## SUBMISSION 2: SUMMARY OF ADDITIONAL CONCERNS IN RELATION TO THE PROPOSED NORTHCONNEX TUNNEL

Application number - SSI 13\_6136

**This is an objection to many aspects of the proposed NorthConnex tunnel.**

MOTORWAY OPERATIONS COMPLEX - SOUTHERN VENTILATION FACILITY - SECTIONS
M1-M2-5000-DR-JD-0525

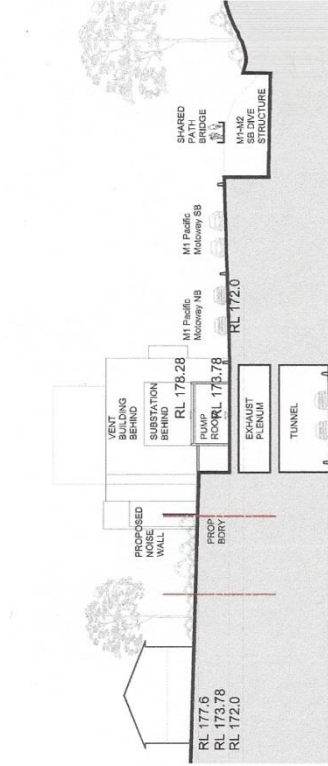
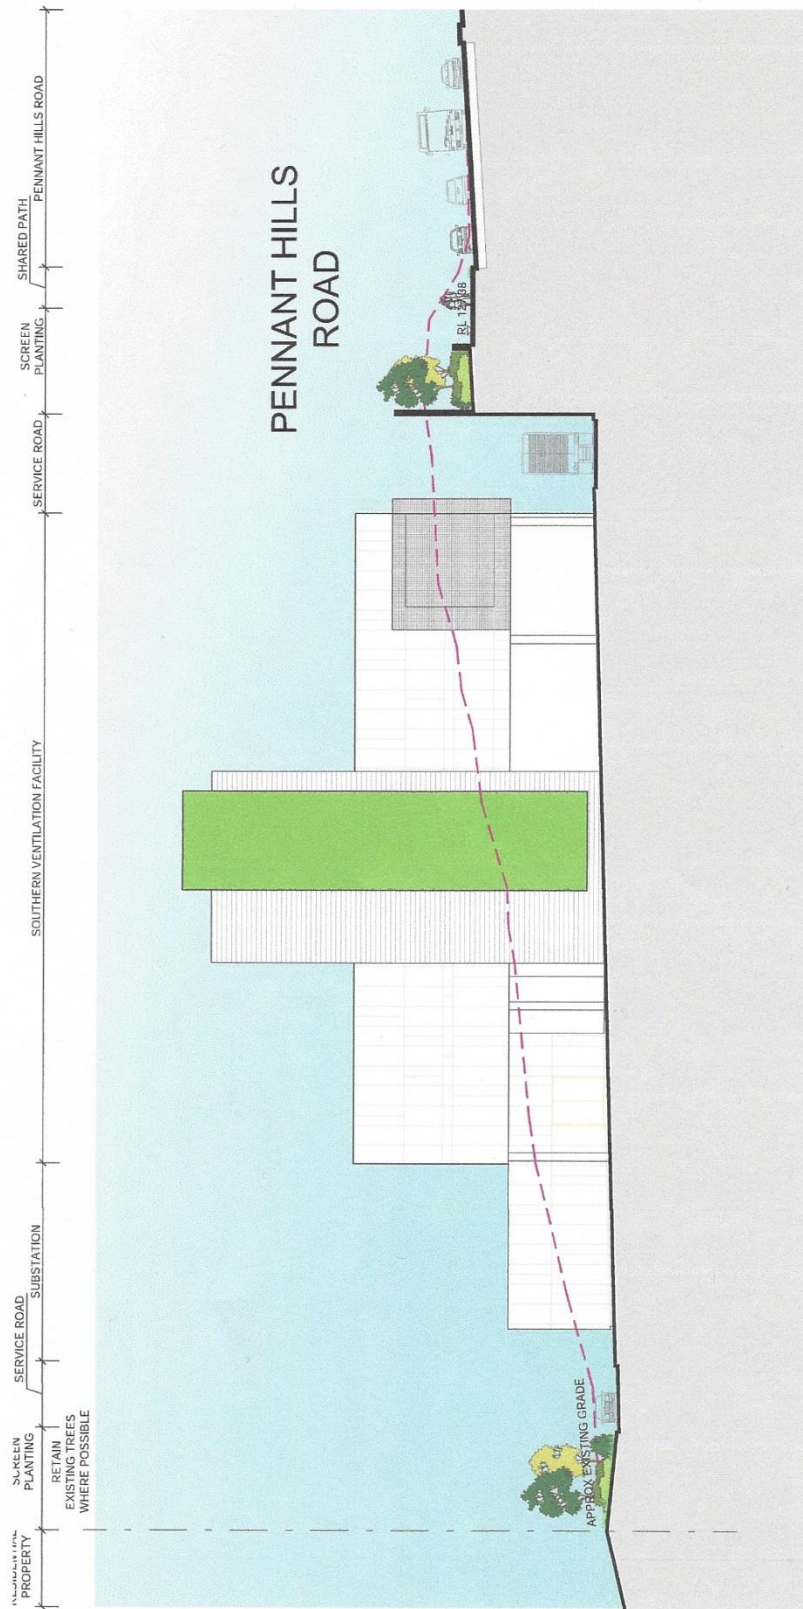
Speakers at the NorthConnex Air Quality Forum spoke of the importance of the topography in the placement of the ventilation facilities. In the NorthConnex proposal the southern ventilation facility is at the lowest point of the M2 intersection where it is surrounded on three sides by hillside cuttings. In this location the “discharge point” will barely be above the adjacent high ground.

Much is made of the intention to discharge the polluted air through the stack at 13 – 19m/s. Given that the stack is only 15m above Pennant Hills Road, a simple calculation indicates that the particles will be ejected to a height of between 23m and 33m above Pennant Hills Road. That will only be sufficient for them to be dispersed by prevailing winds IF there is wind and it is strong enough. For instance, the weather history graph showing the wind speed and direction at West Pennant Hills measured on the 24th August 2014 indicated that there was no wind until 9am and what wind there was, came from the west. Wind speeds of less than 2m/sec (ie about 8km/hour) are not considered sufficient to disperse pollution from the stack. Only a very few gusts on this day were in excess of 8km/hour.

That the Government ensures that the southbound ventilation facility ie the Stack, be located at the south-west corner, on the RMS owned land, at the edge of the Pennant Hills Golf course. In this location, the southbound tunnel can be efficiently, effectively and economically ventilated.

The impact of the stack plumes on the surrounding residential areas must be modelled using its current proposed position and height and also modelled with the stack positioned on the golf course side of Pennant Hills Road, where it is topographically higher. This would allow an objective, impartial, scientifically based assessment to be made of the most effective location for the stack.

MOTORWAY OPERATIONS COMPLEX - SOUTHERN VENTILATION FACILITY - SITE SECTION 1-1
M1-M2-5000-DR-UD-0713

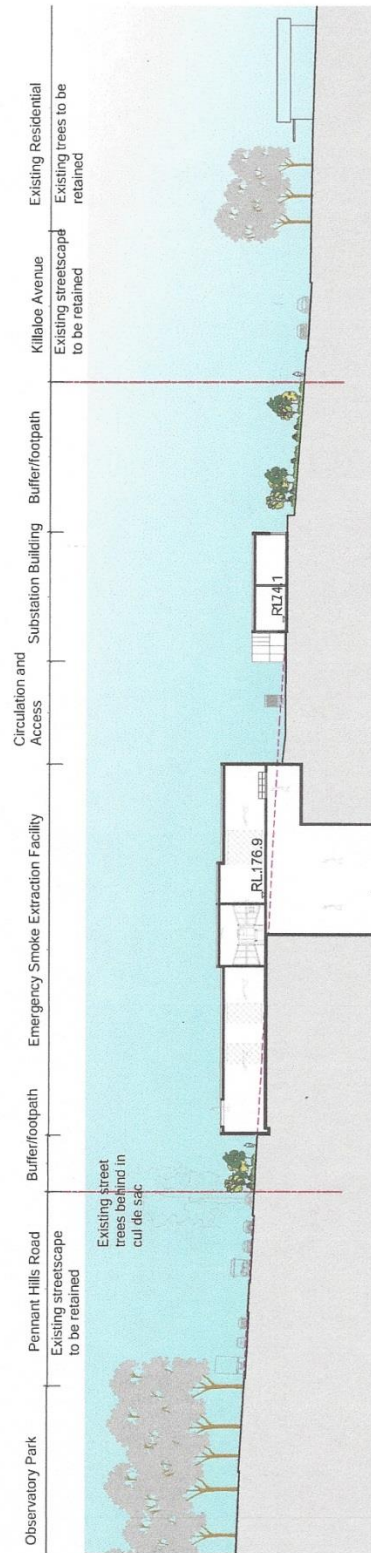
### **How can this be the most suitable position for the outlet when land that is more suitable is already owned and available?**
